Current Zoning: N1-A and R-8MF(CD)
Proposed Zoning: R-8MF(CD) and R-8MF(CD) SPA

Approximately 21.12 acres located along the southeast side of Mallard Creek Road, west of Penninger Circle, and north of Morris Estate Drive.

The petition proposes to rezone one parcel to add an additional 4 townhome buildings for a total of 20 additional townhome units to the project and 116 units total for the site. This rezoning plan was previously approved under rezoning petition 2020-099.

Rezoning Plan
Petition # 2022-205

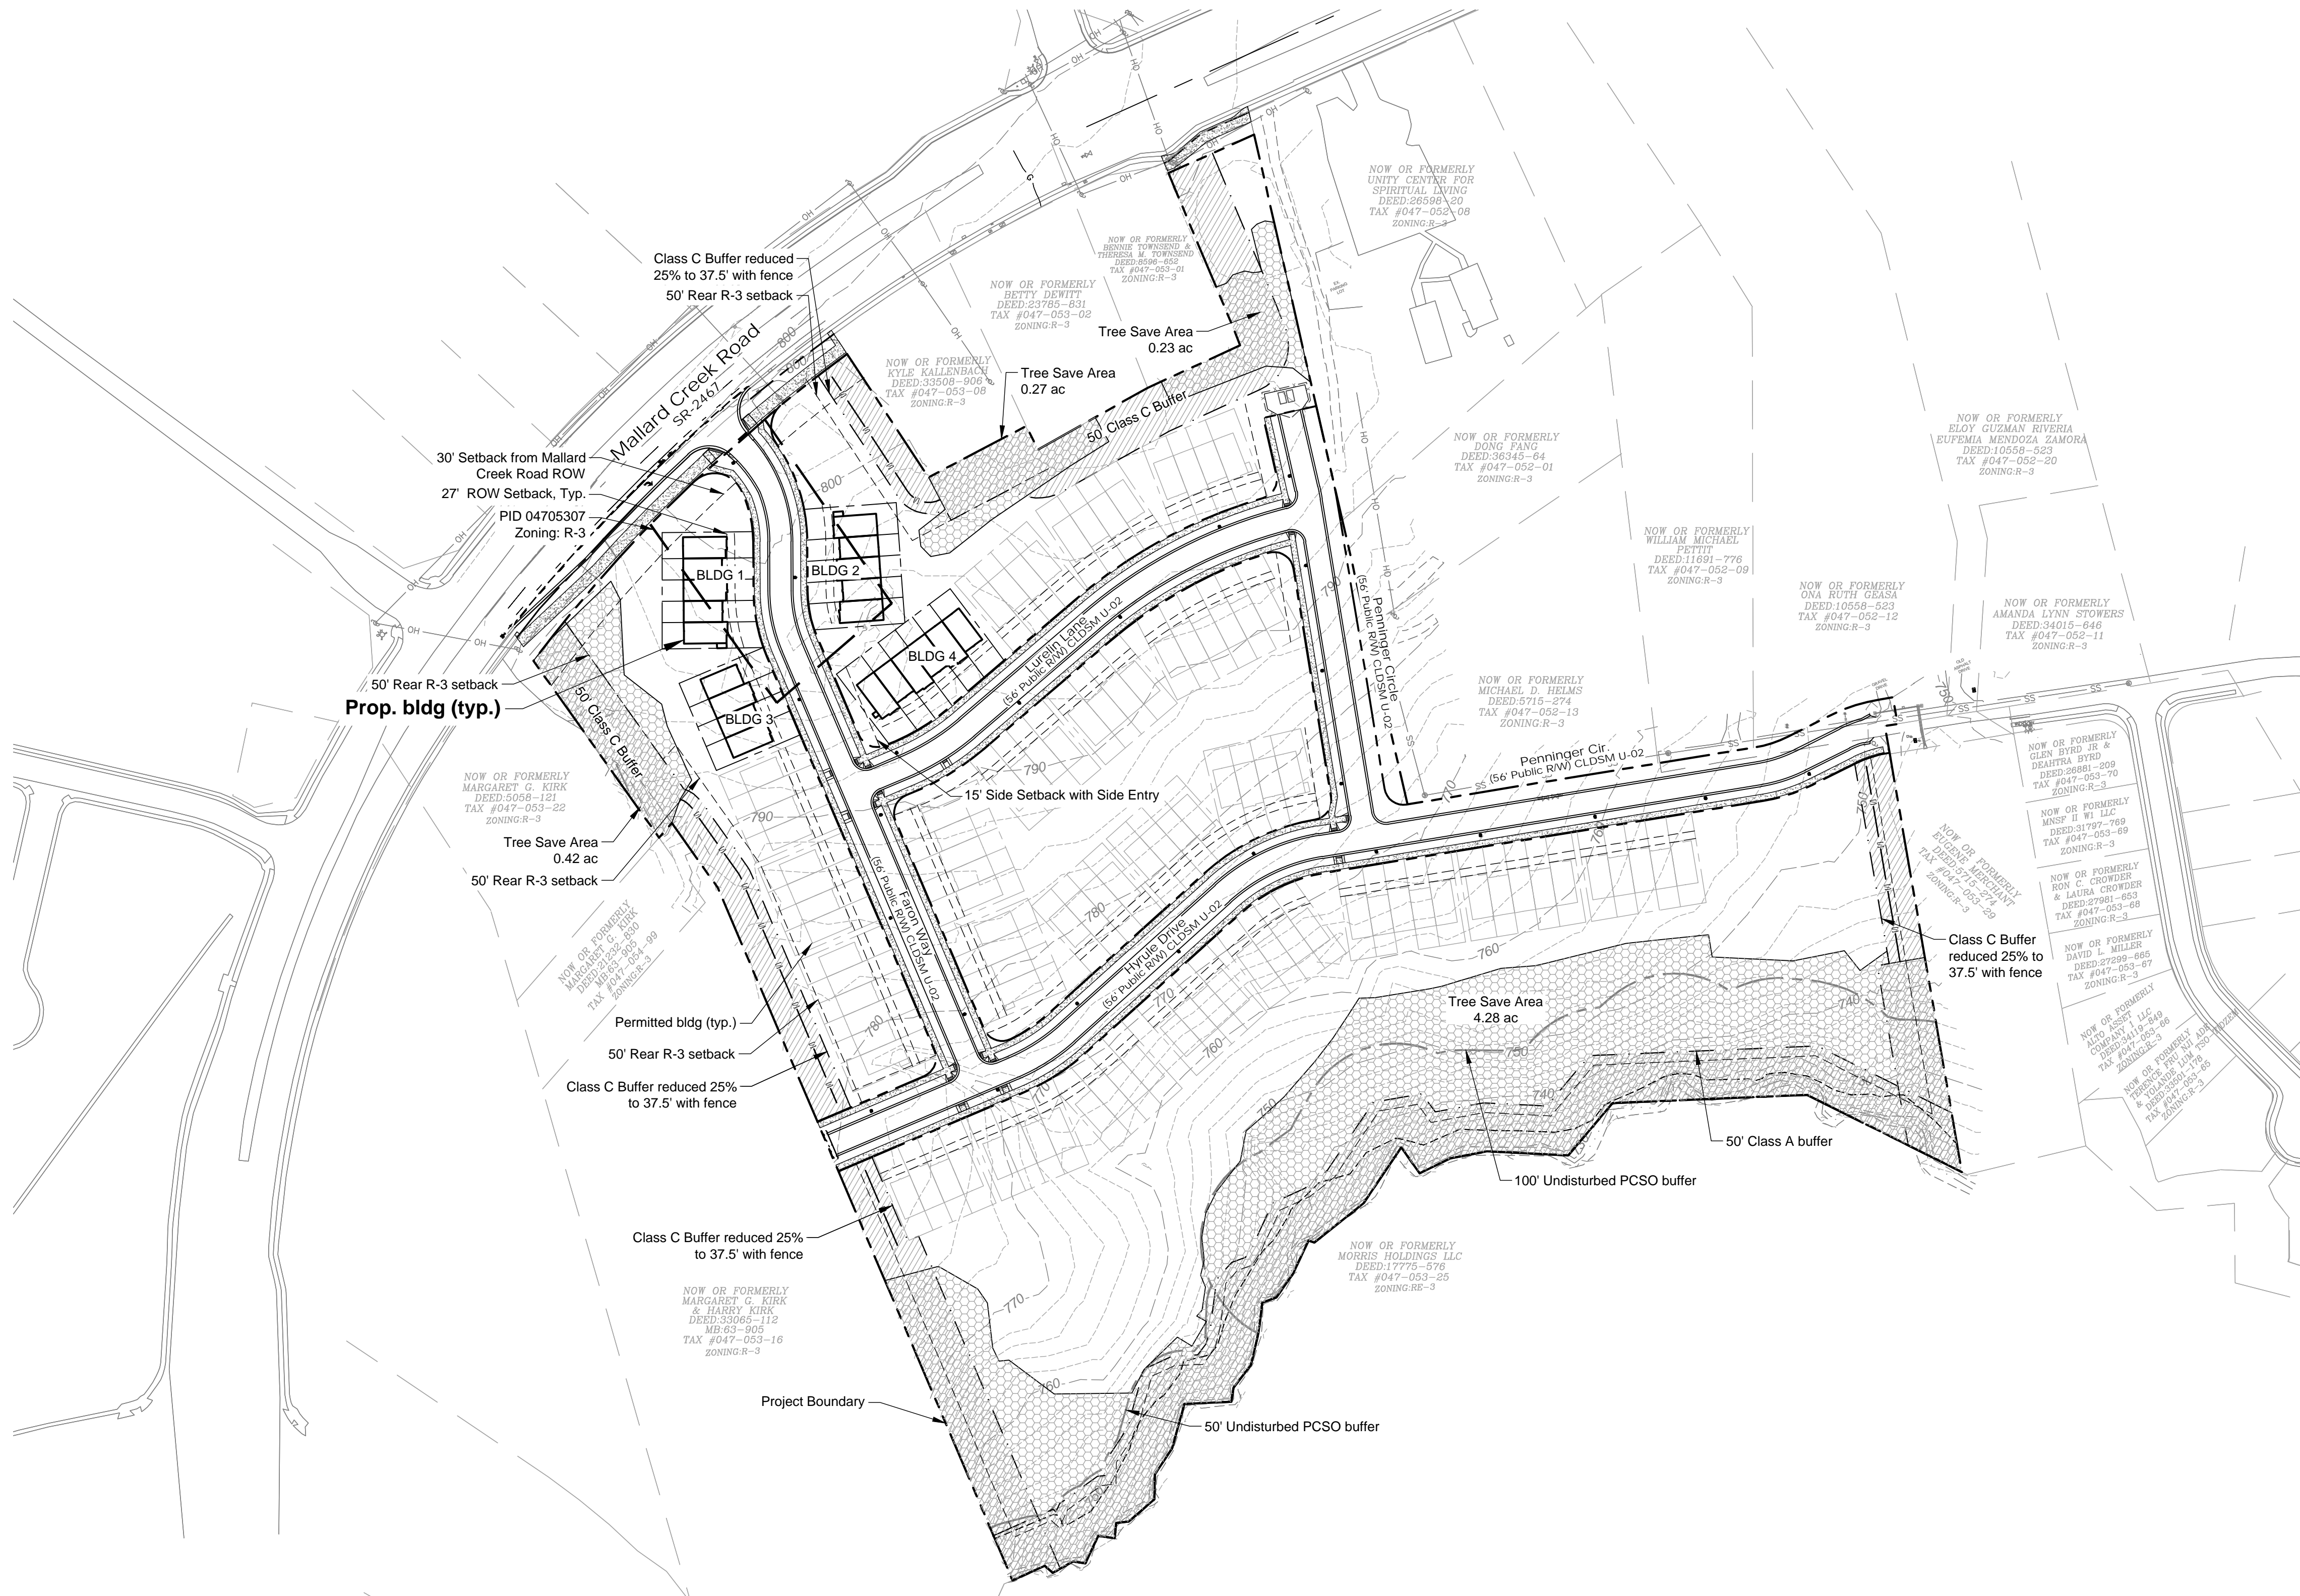
1. ~~Label and dimension the curb and gutter from the centerline for each road on the site plan.~~ Addressed
2. ~~Revise site plan and conditional note(s) to commit to dedicate 50 feet of right of way from the road centerline. The site plan shall label and dimension the right of way from the road centerline.~~
